**Gatwick Airport Northern Runway Project
Development Consent Order
Planning Inspectorate's Reference: TR020005**

**Deadline 6 Representation from Rusper Parish Council
Re Noise Contours & Proposed Revised Noise Insulation Scheme**

Title:
Ordnance Survey Base Map Identifying Category 3 and Noise Insulation Scheme Boundary - Sheet 1 of 4

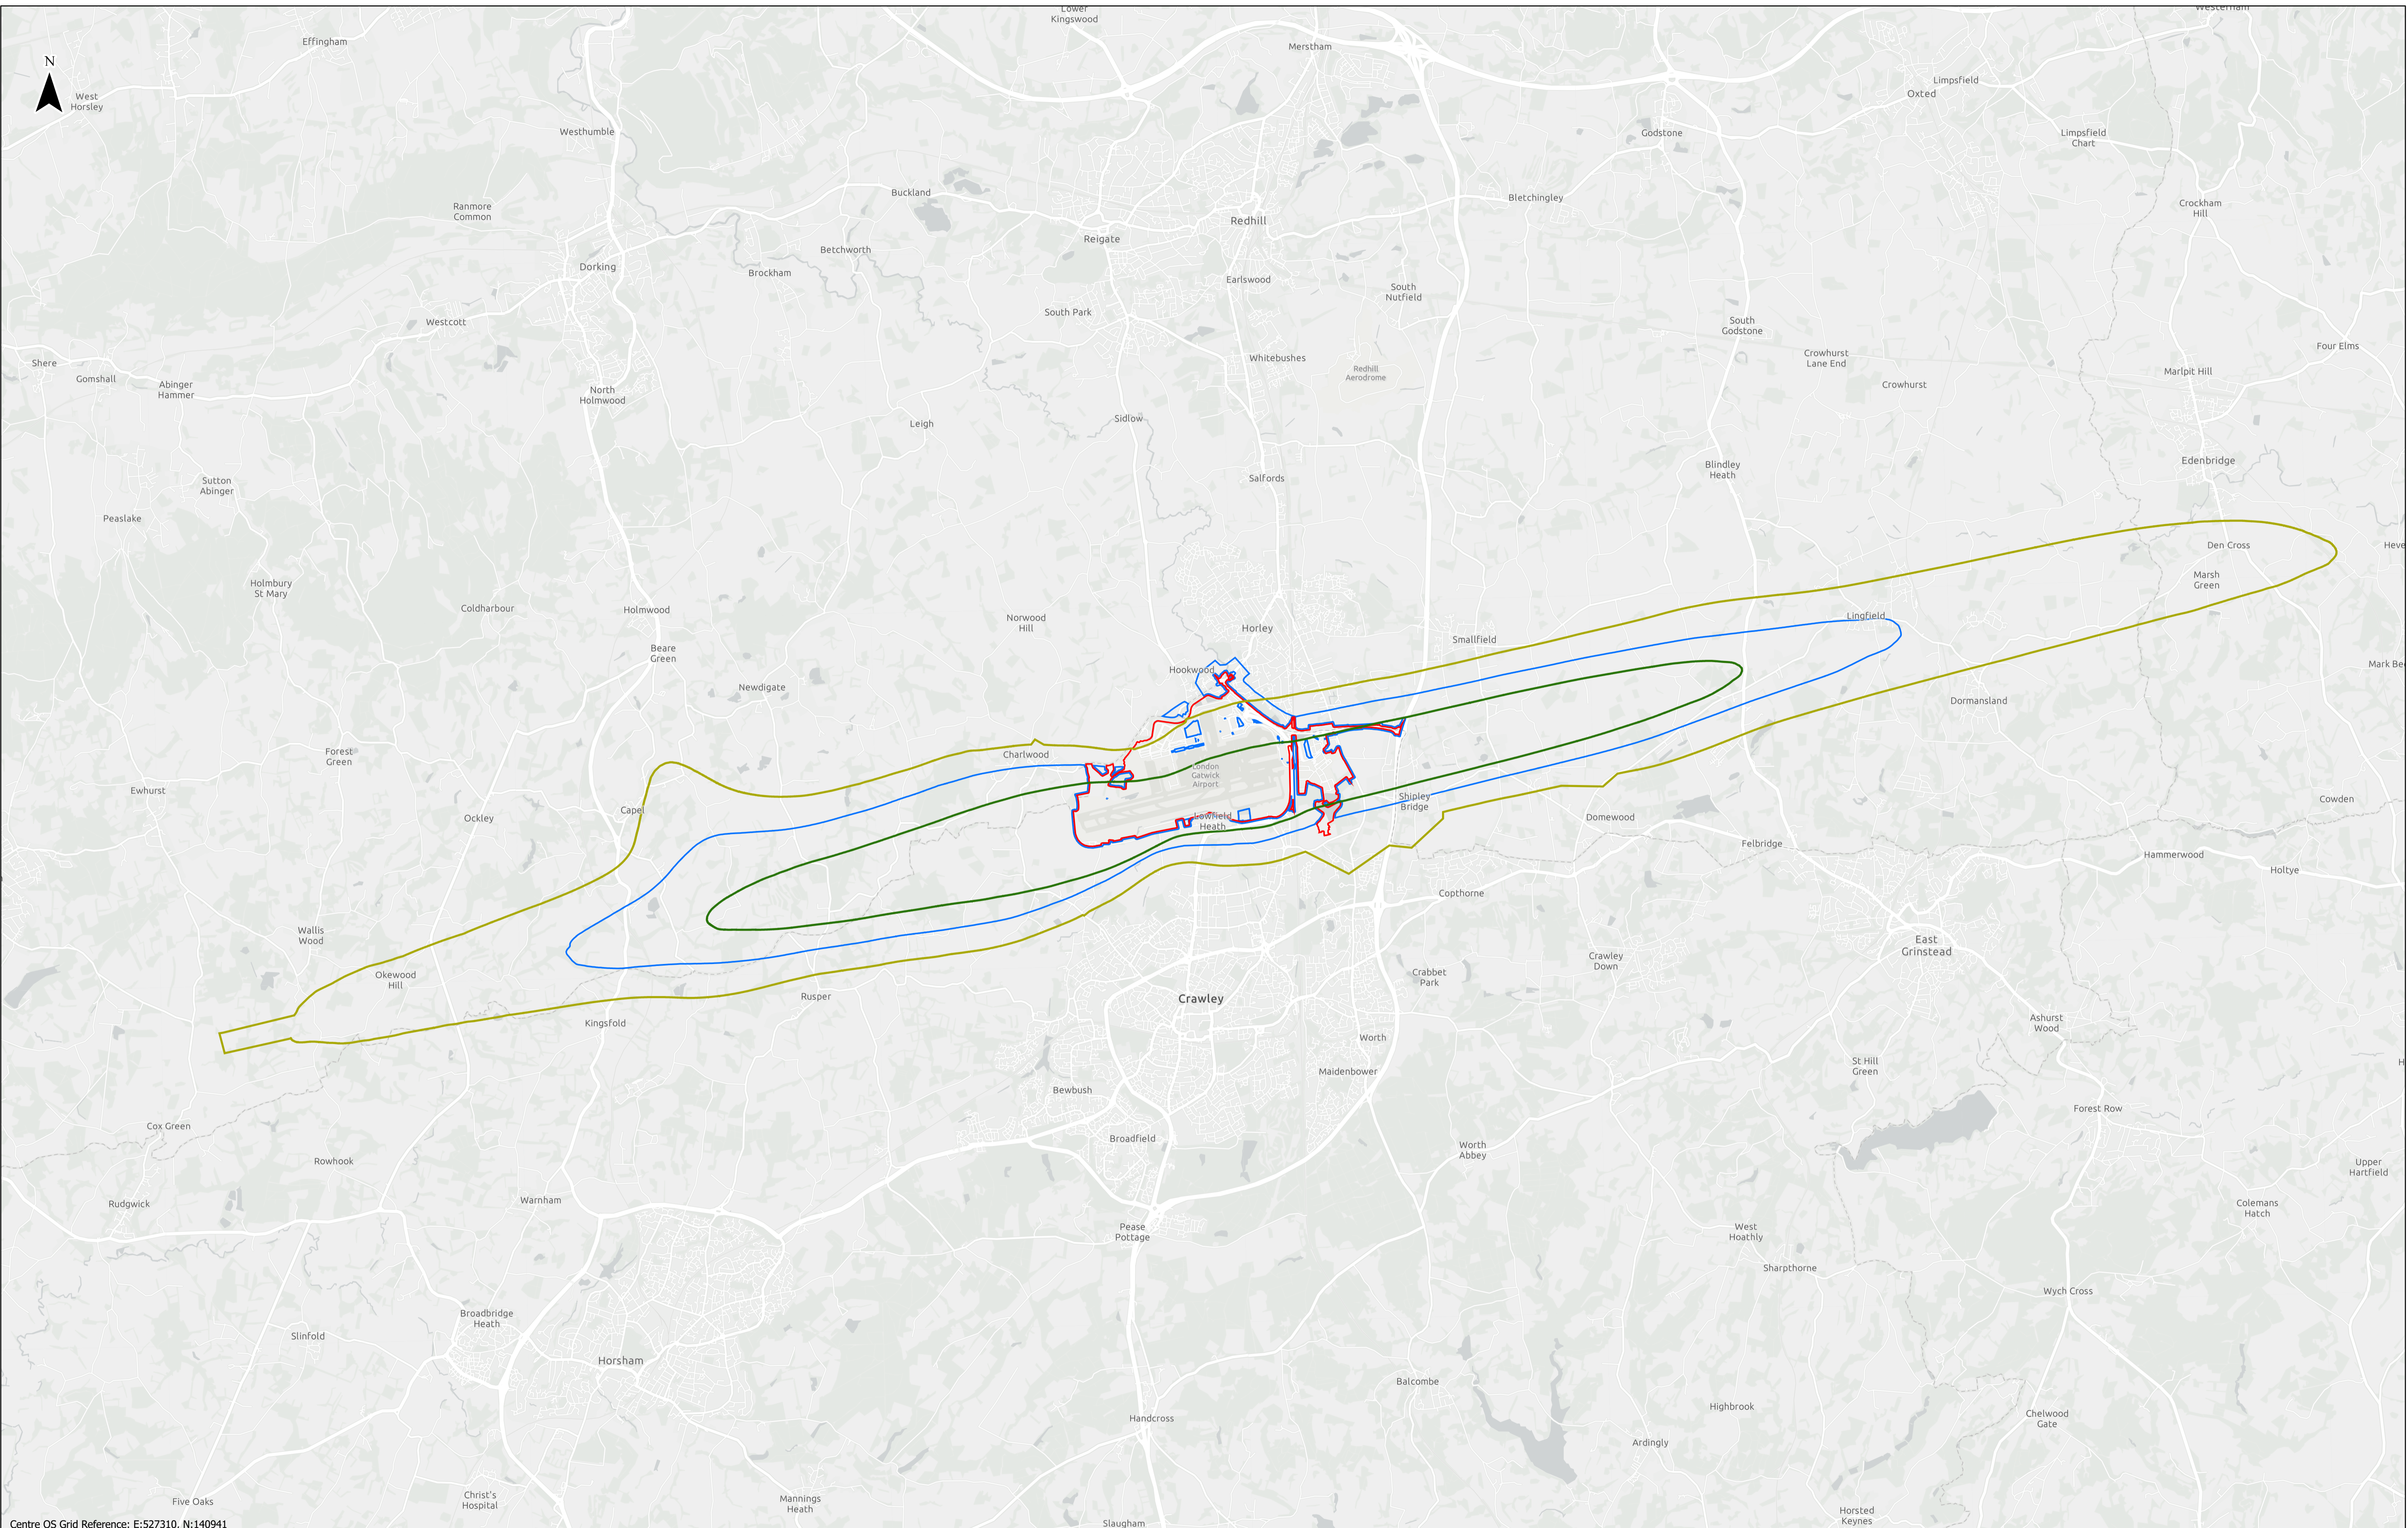
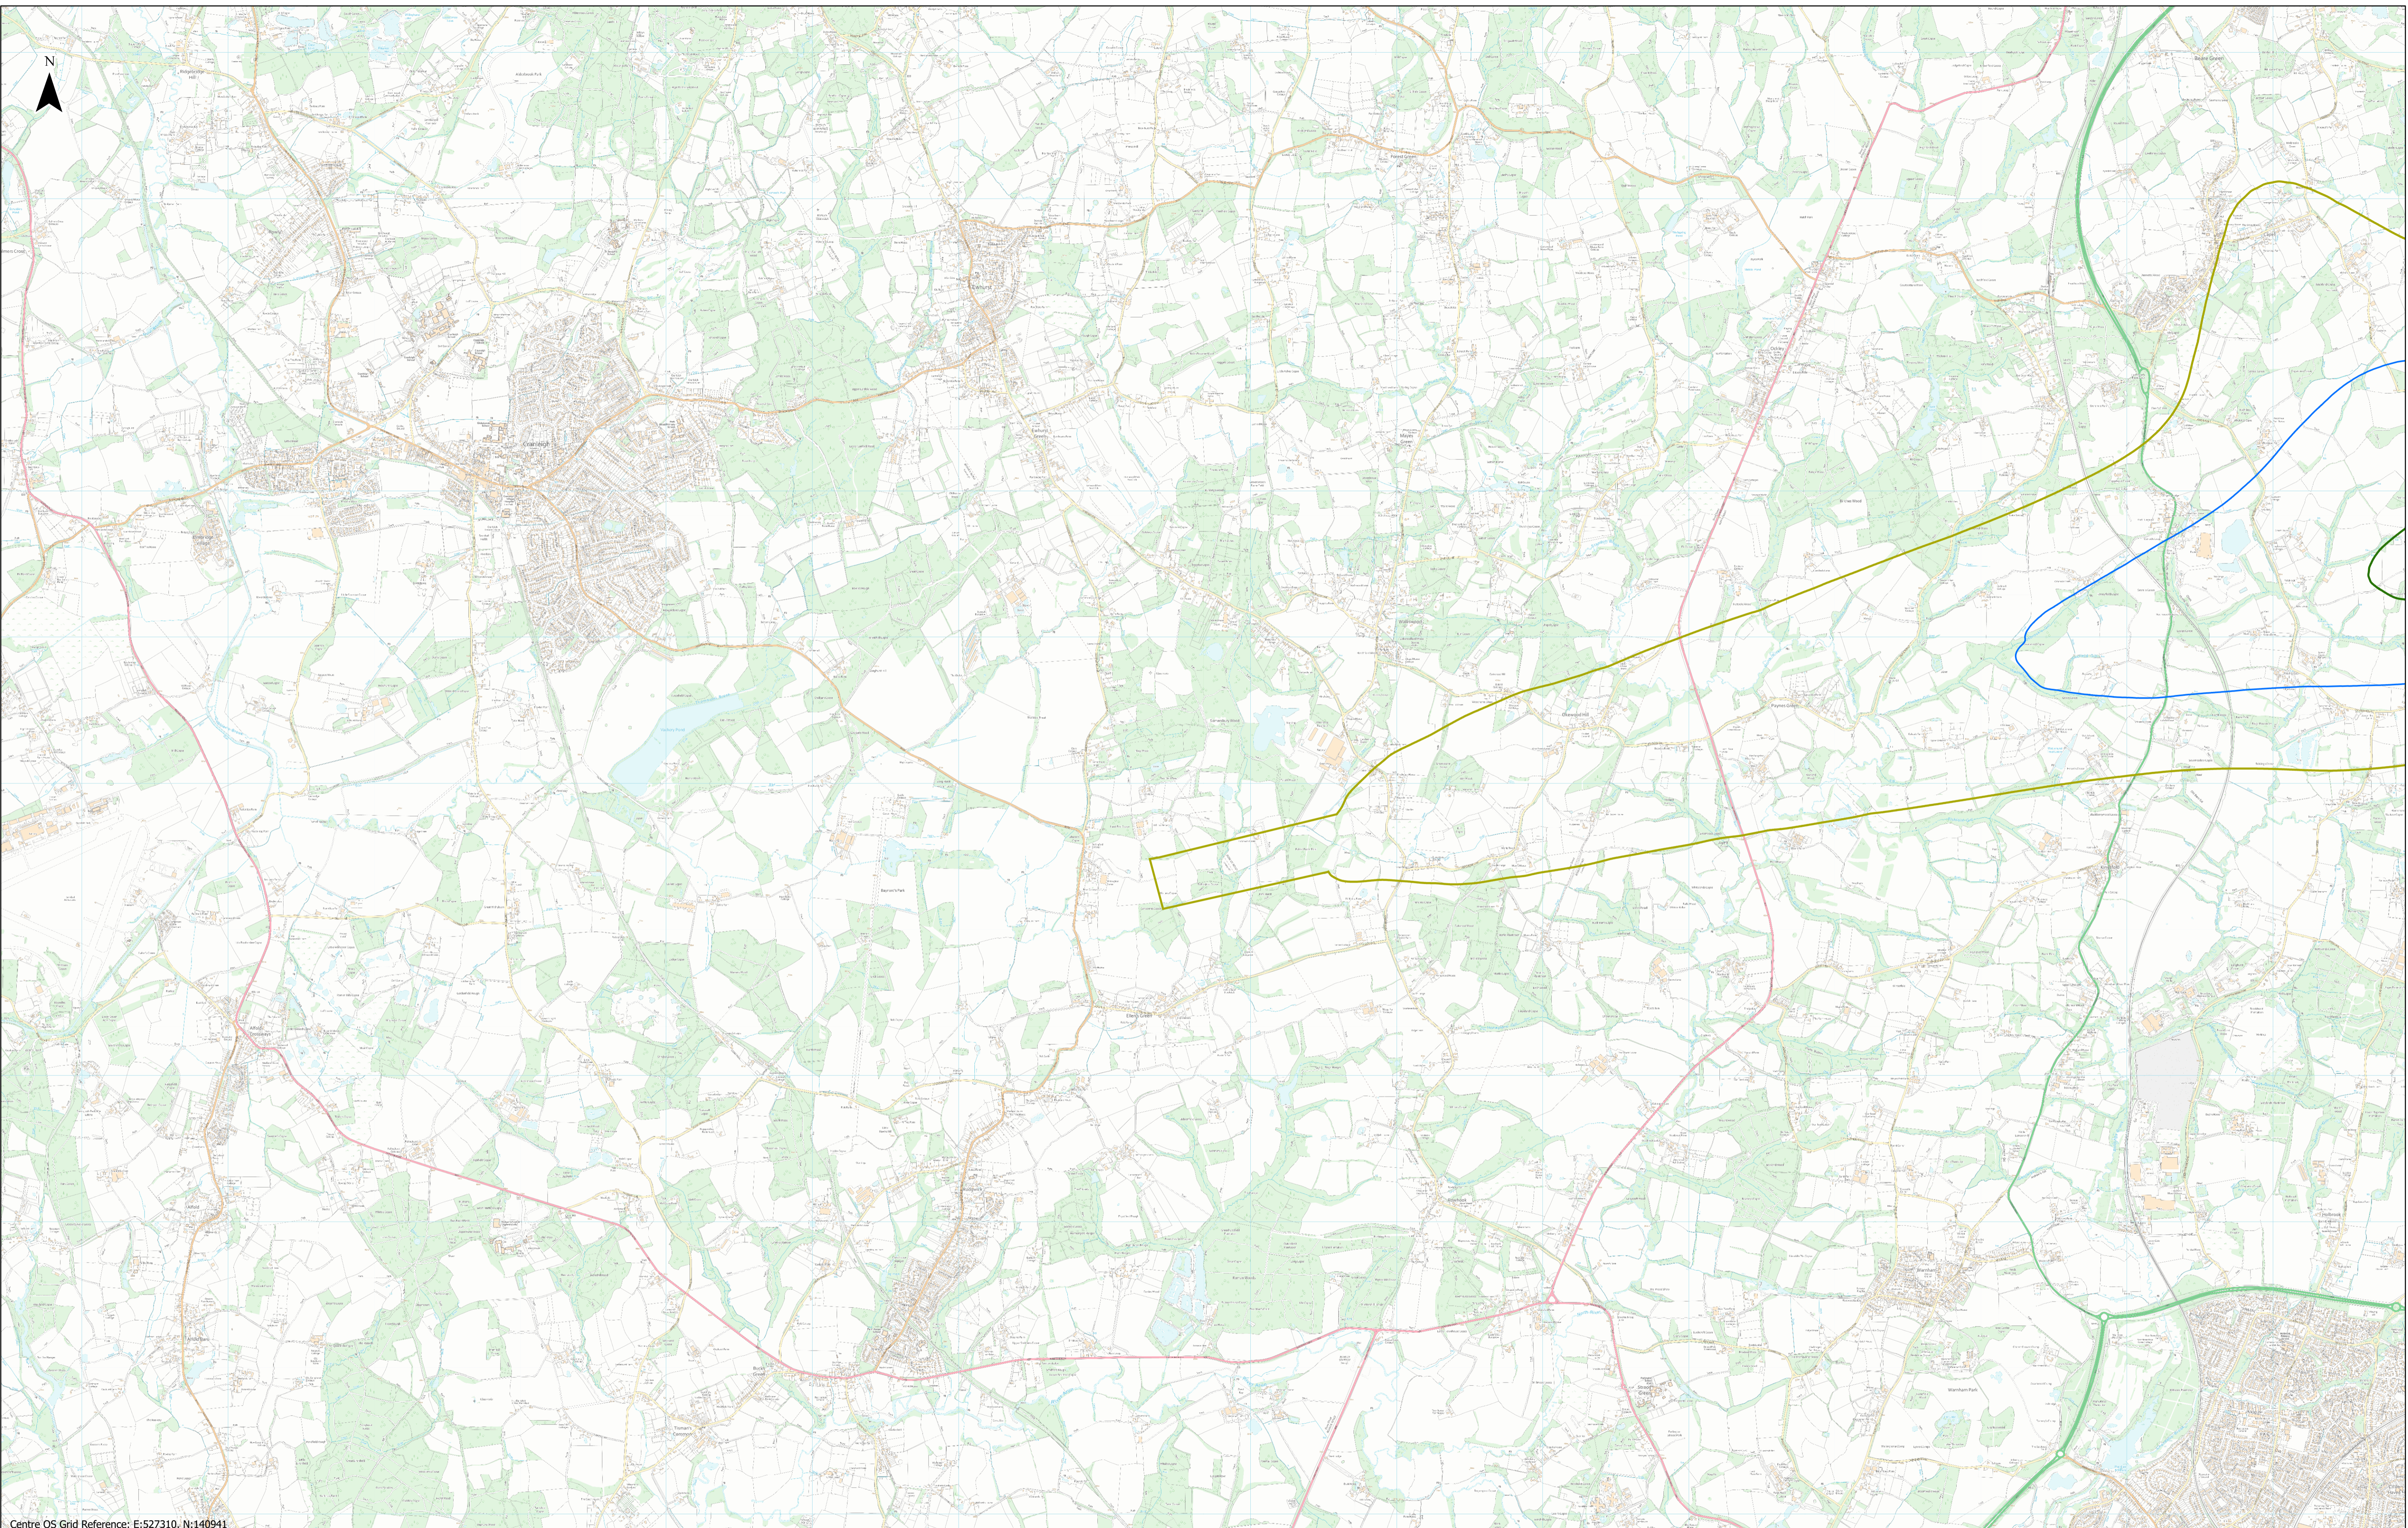
We would also wish that the Noise Contour maps be materially upgraded since it is extremely difficult to ascertain precisely where the contours are. It is not made clear when these contour maps were compiled nor the data used in their compilation. It is thought they may simply have been prepared at the time of the Second Runway proposals in 2014.

More particularly, since detailed interpretation of the proposed contours is problematic, Gatwick should set out their proposed contours using Google maps (or similar) so that the position of roads and individual houses are made much clearer.

One issue which needs clarification is that Gatwick states their present scheme operates within a boundary of 60dB daytime Leq, whereas it would seem that their proposals now revert to 63dB daytime Leq. Since this effectively reduces the size of the noise contour and thus the eligibility of residents who were within the 60dB contour but not within the 63dB contour, the change is not explained nor justified.
